Application for a non-material amendment following a grant of planning permission.
Town and Country Planning Act 1990

Proposed 2 four-bedroom houses

H13-0283-16

Omission of parapet walls along side gable of houses. Window design changes to reflect working drawings.

Drawing No L158/PLOT 2/06	Rev.
------------------------------	------

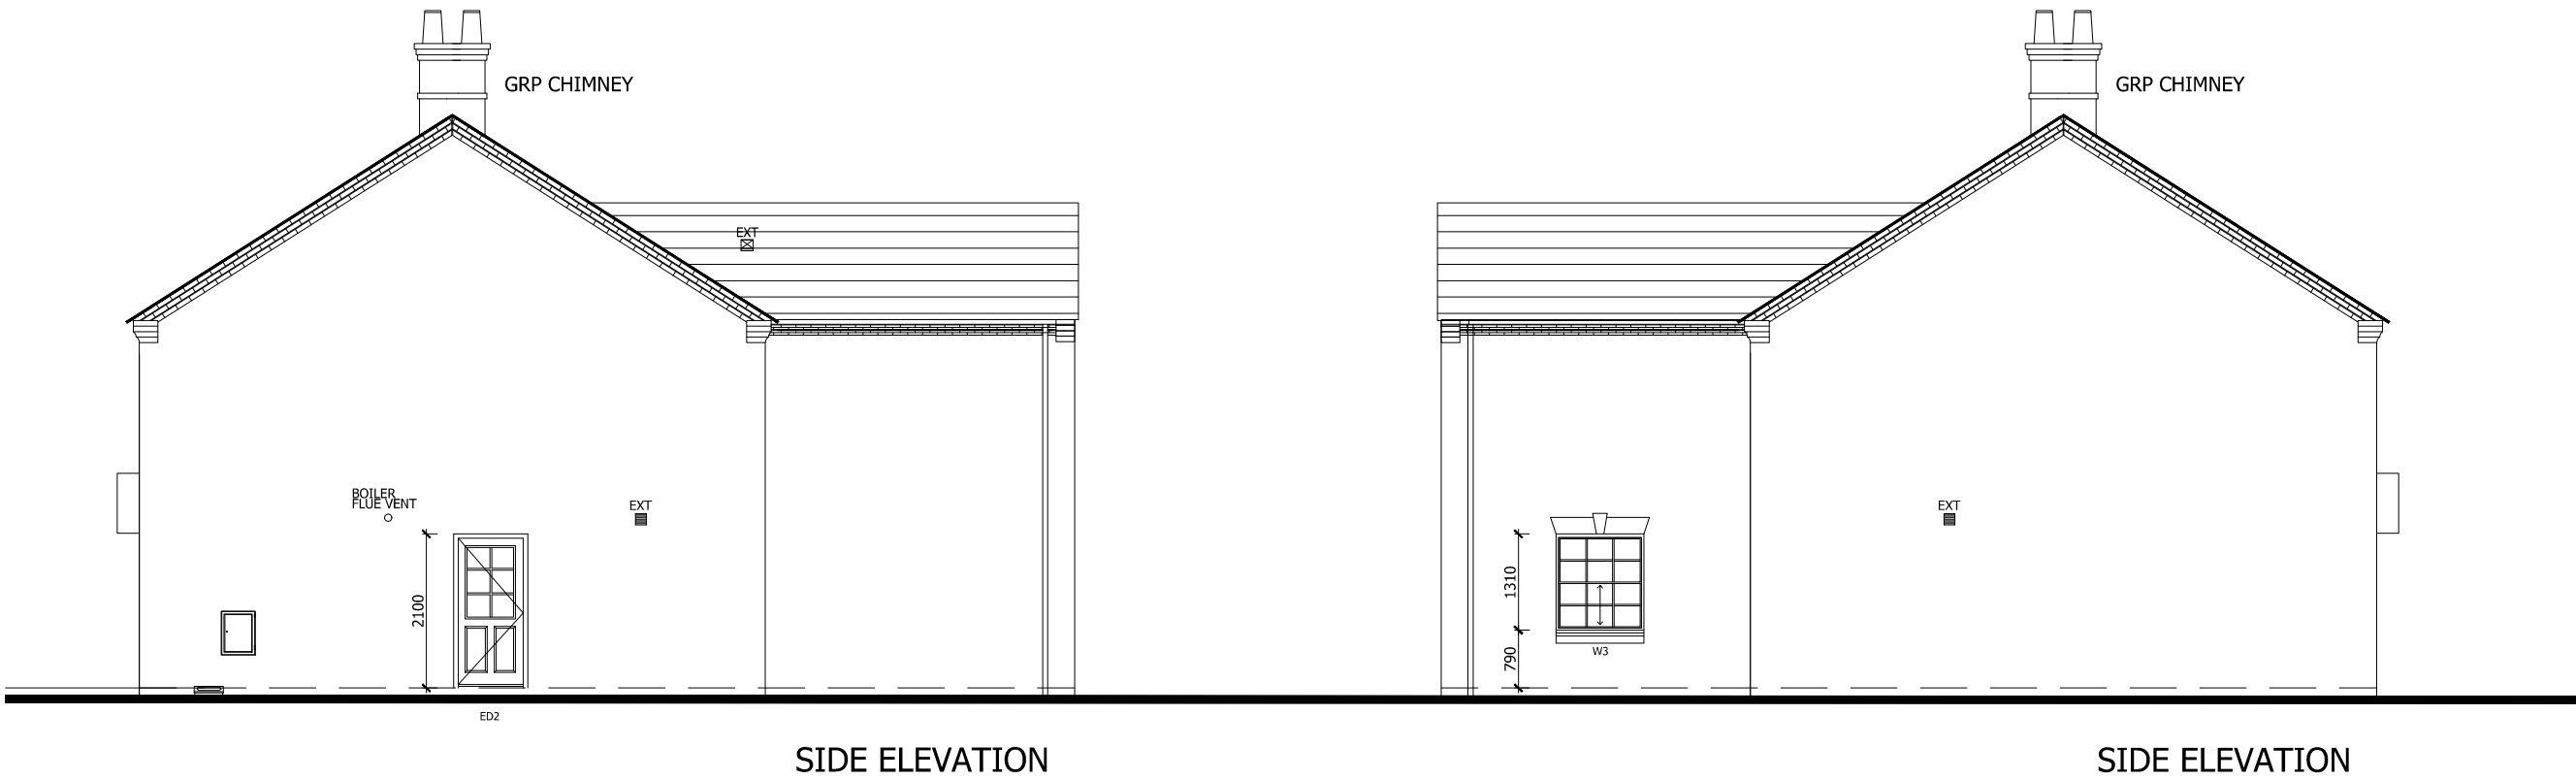
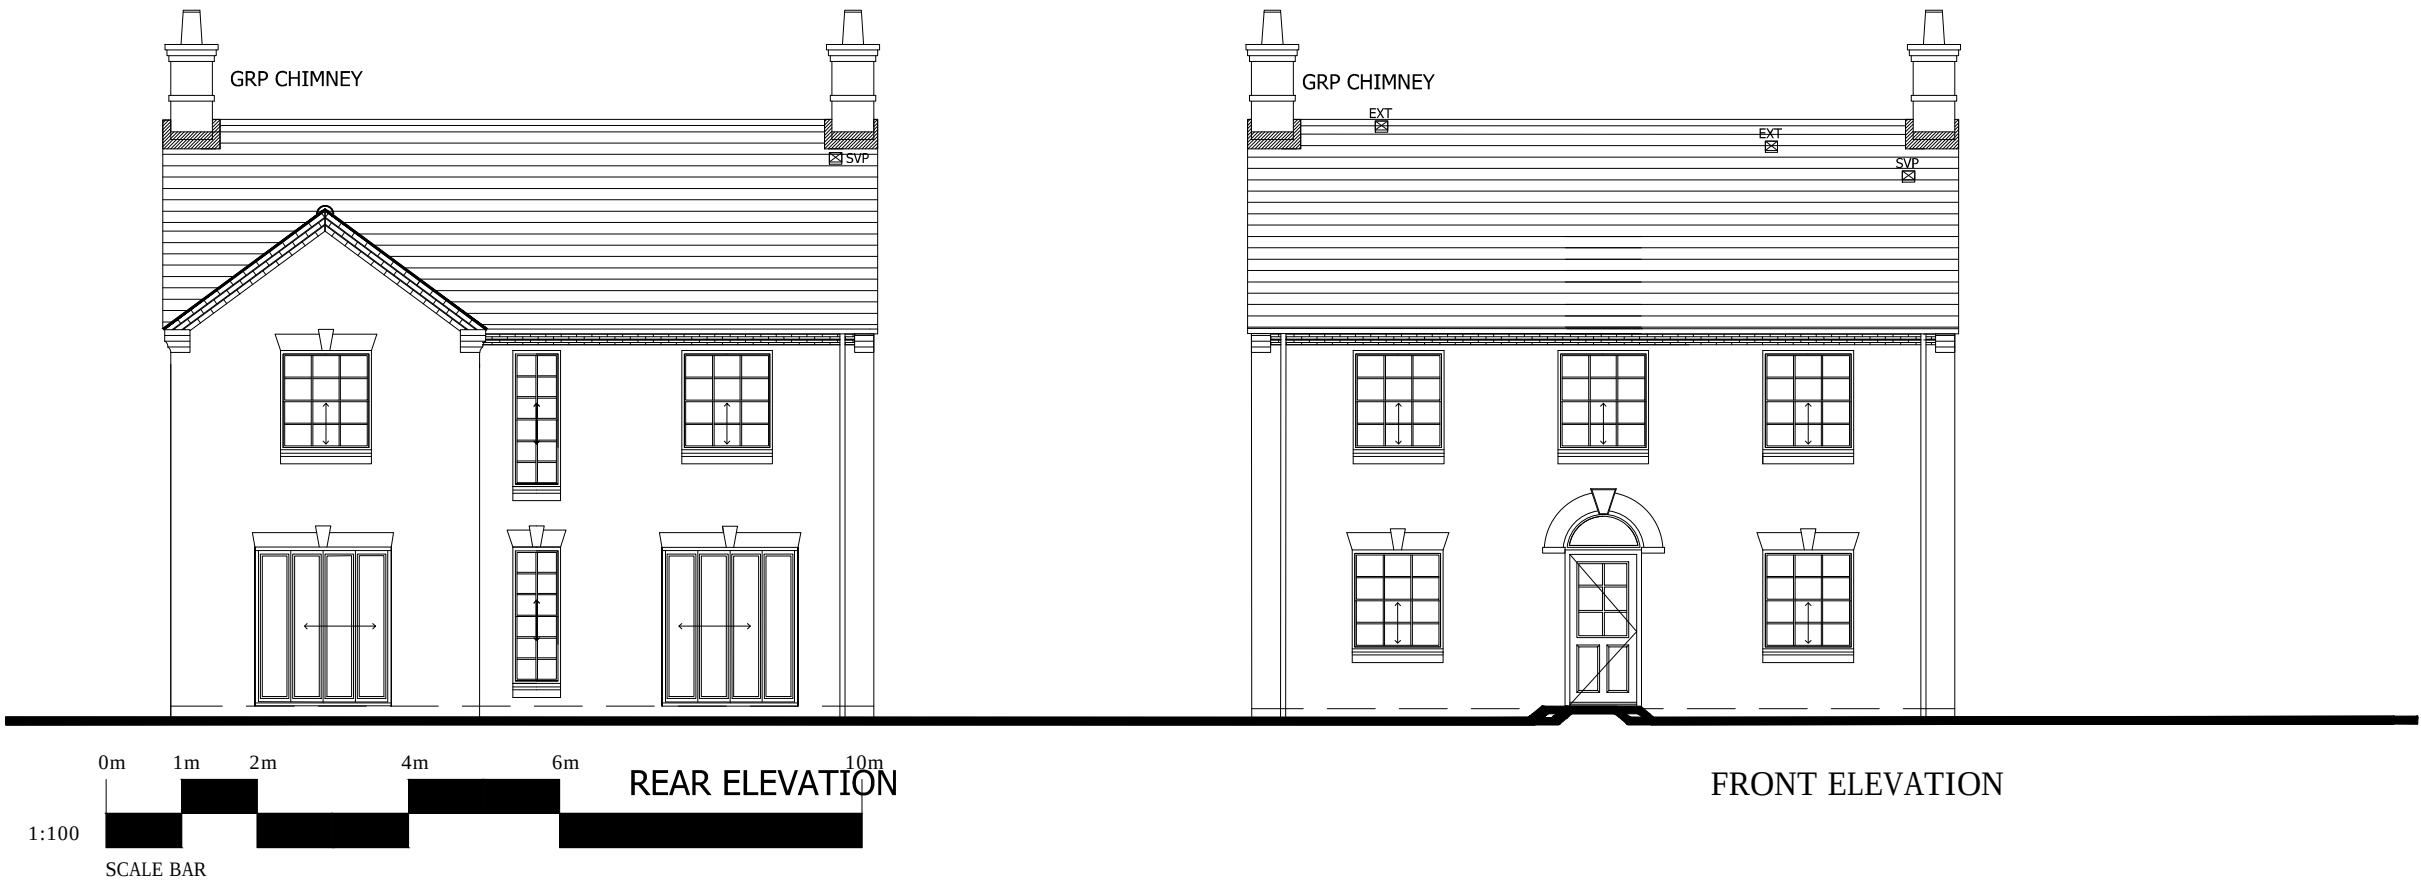
Once the plans were approved, the drawings were taken to the detailed technical design for the house types. Issues were raised in getting the GRP chimney working with the parapet detail on the houses.

Whilst drawing the elevations, alterations were made to the windows of the houses to work best with the property in providing sufficient light to each room and hallway whilst allowing for reasonable window widths for the central hallway.

Once the house details were drawn to correct building heights, this resulted in changes to the elevation of the houses in respect of window head design.
